30 June 2016

RE: SSD 7047, Darling Harbour Live Interactive Signage Display System

I refer to State Significant Development Application SSD 7047 for signage in the Sydney International Conference, Exhibition and Entertainment Precinct at Darling Harbour.

6 DIGITAL SIGN T17 WEST ELEVATION

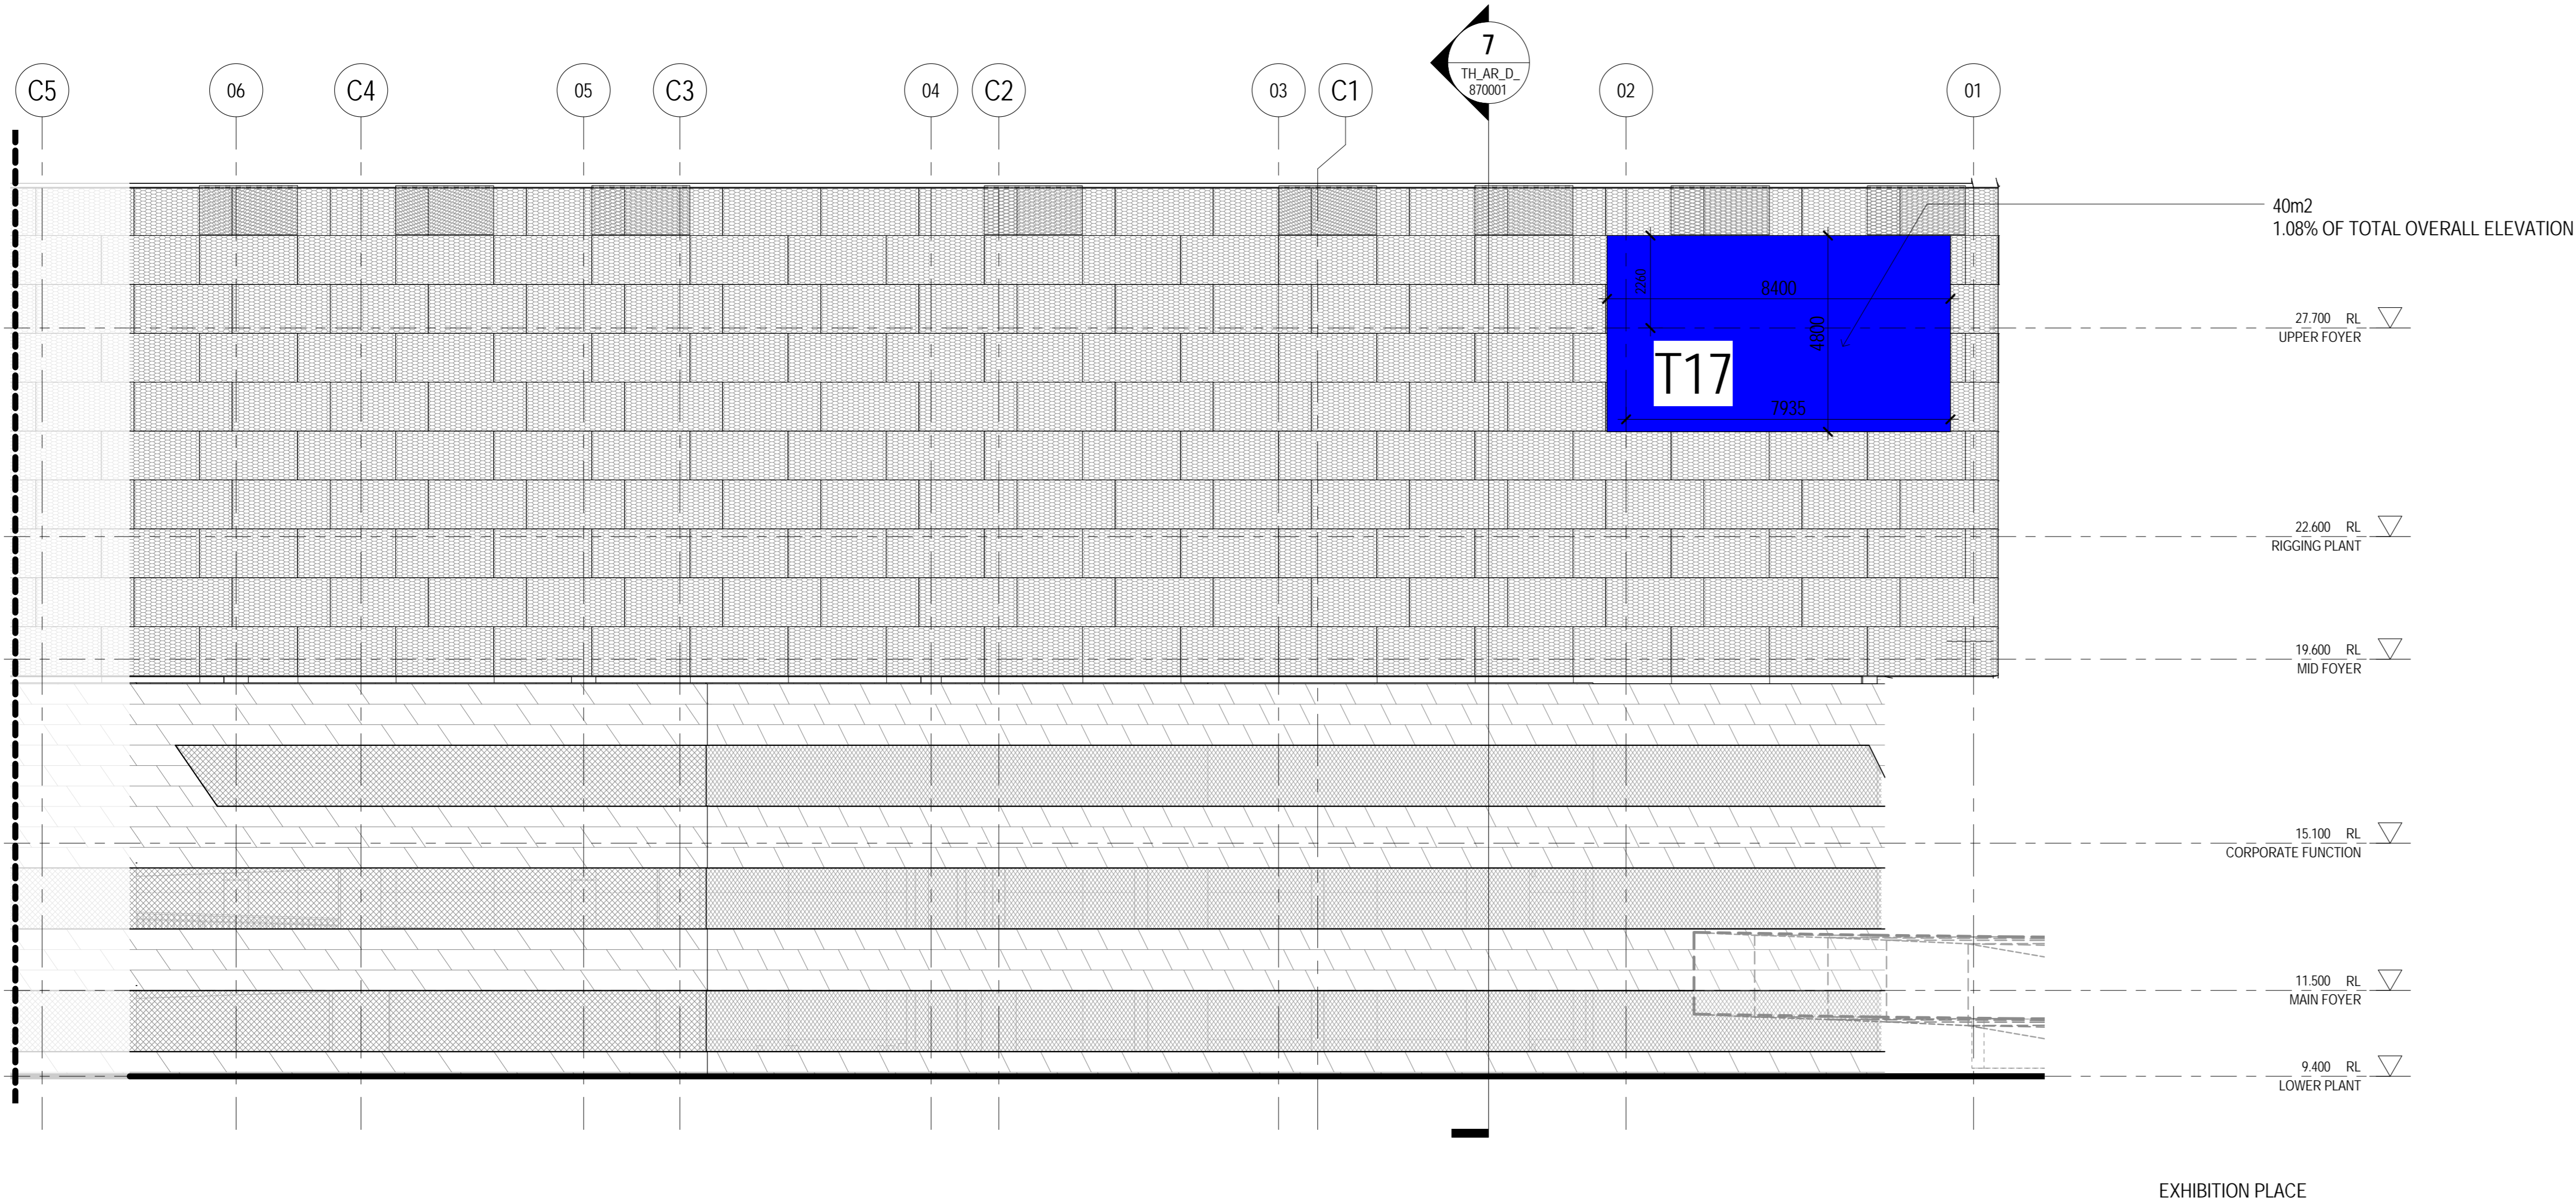
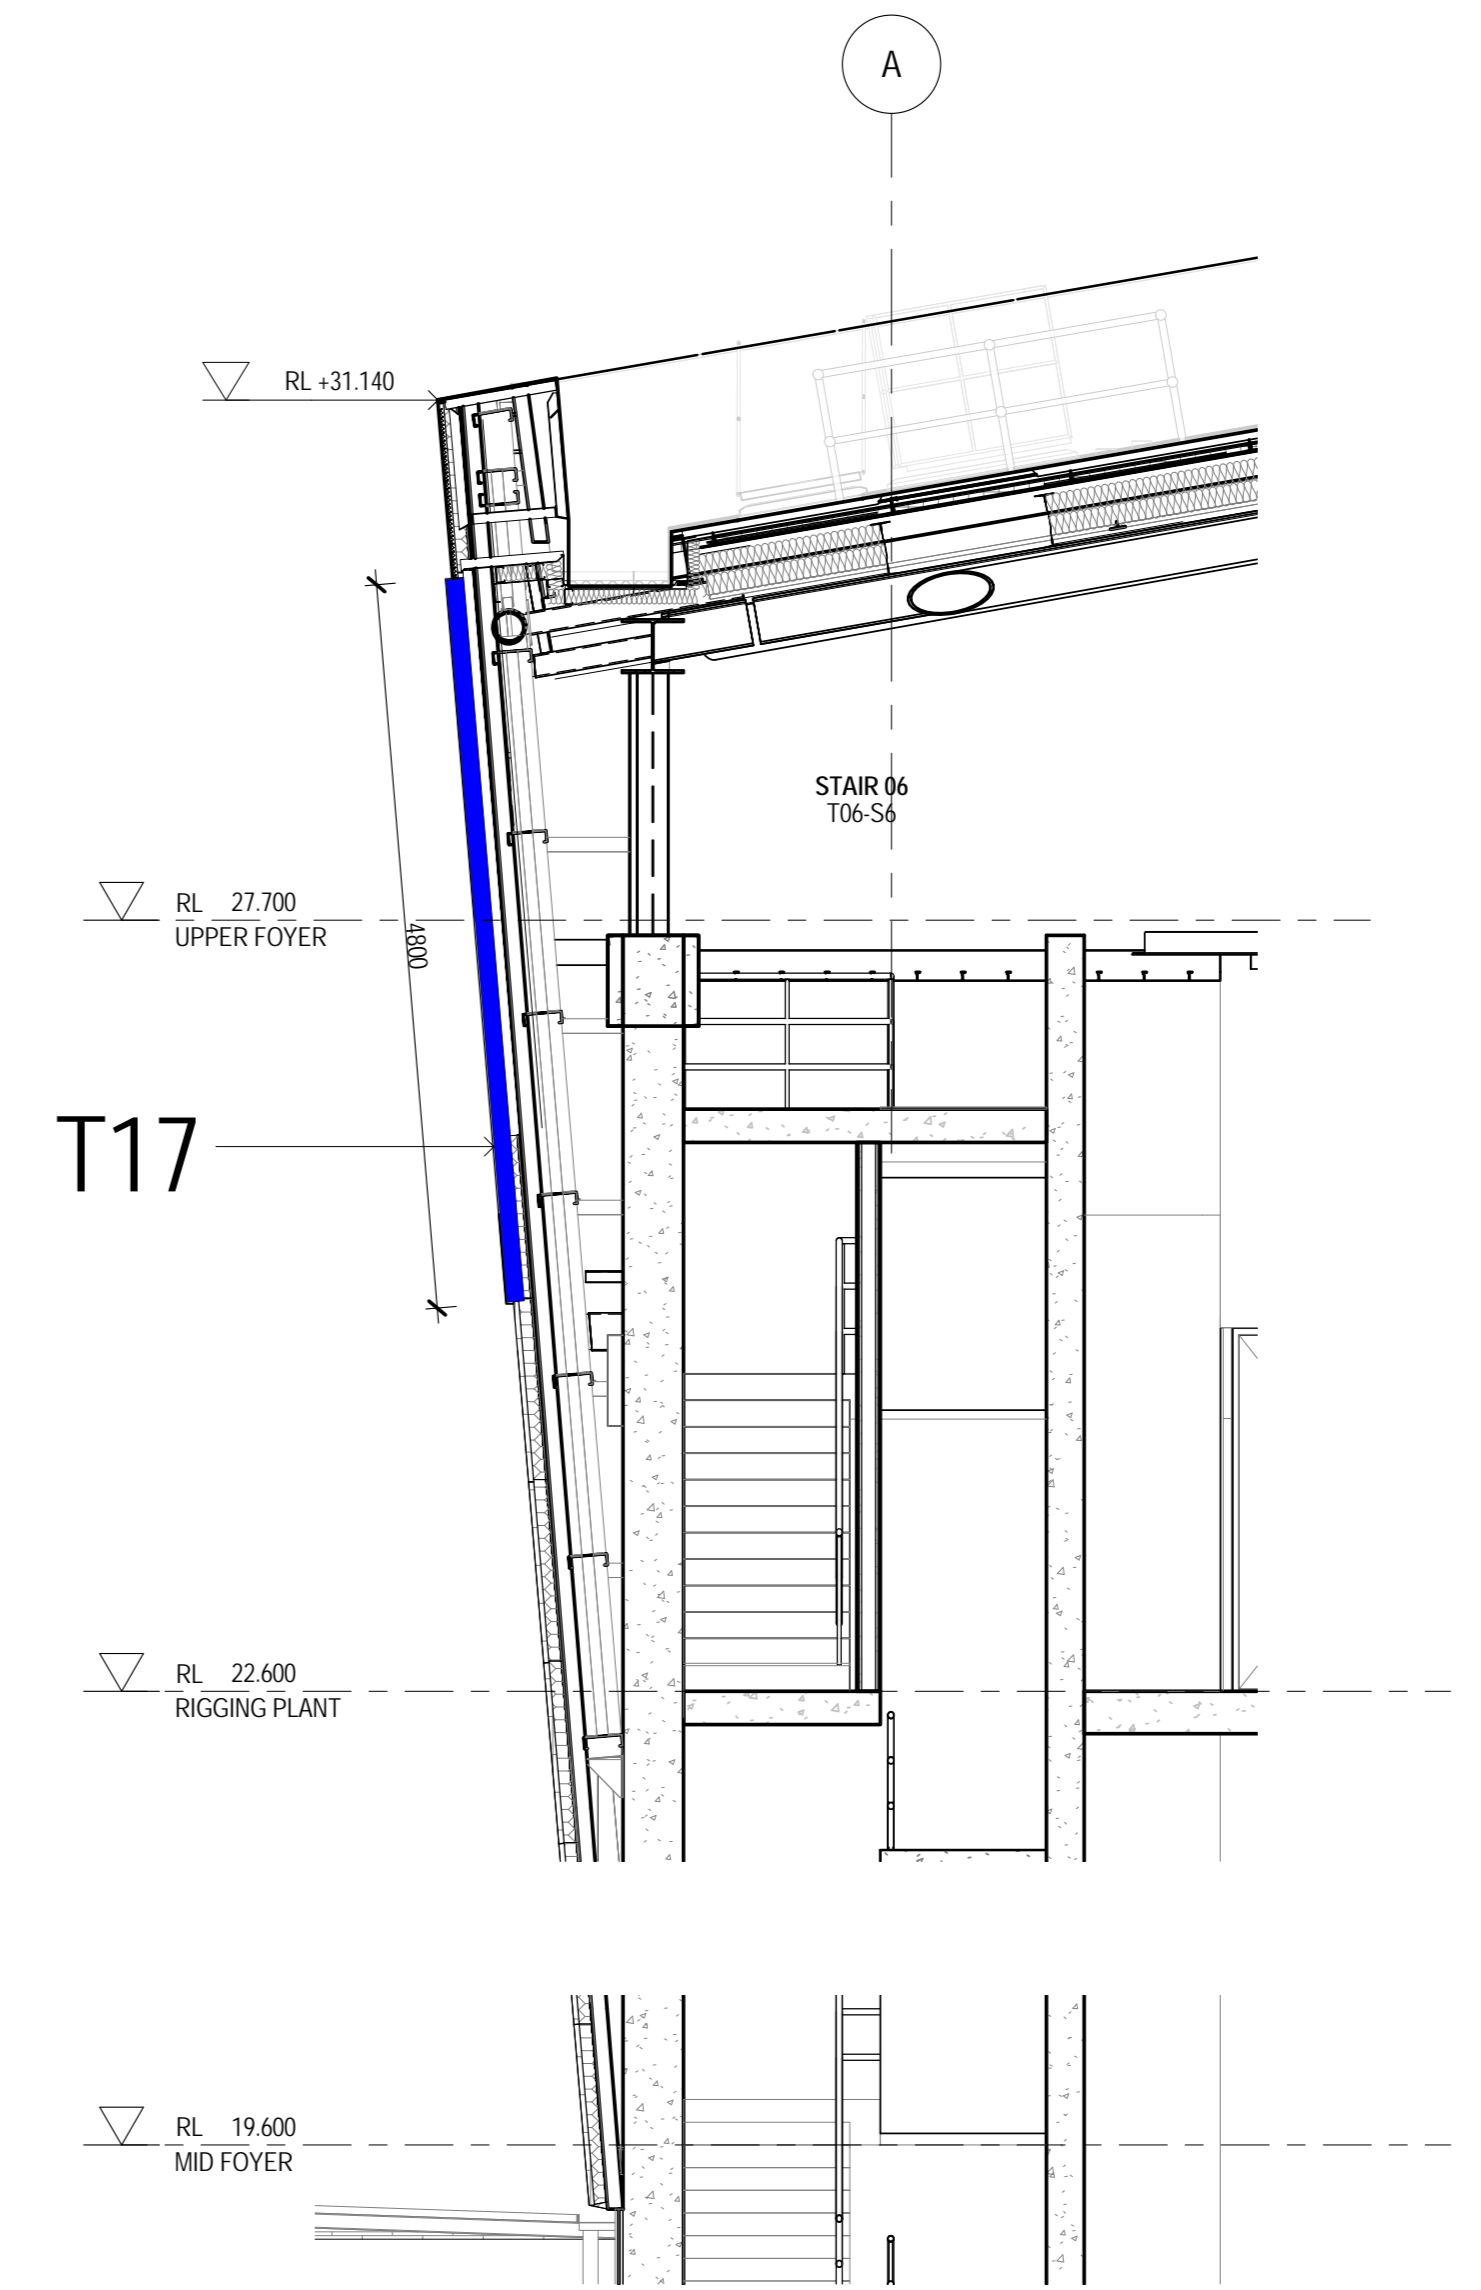
T-17 is a 84m² digital LED screen that is located on the western face of the Theatre that will be used to advertise current and upcoming events at the Theatre, and for third party 'precinct partner' advertising.

The view analysis is inadequate to determine its impact from the CBD, and it is recommended that further analysis be undertaken in relation to light spill, glare and driver distraction to vehicles on roads.

The location of the sign and its size maximises its visibility from the Pier Street overpass. The City has concerns regarding vehicular safety, as there is the risk that the sign will materially divert a driver's attention leading to an increased risk of collisions at this busy city thoroughfare. In this respect, concurrence from the RMS is paramount.

Furthermore, the proposed location of the sign appears to be contrary to the Court's findings in "*oOh! Media Assets Pty Ltd v The Council of the City of Sydney and Anor* [2015] NSWLEC 1269" relating to impacts of commercial billboards on vehicular safety.
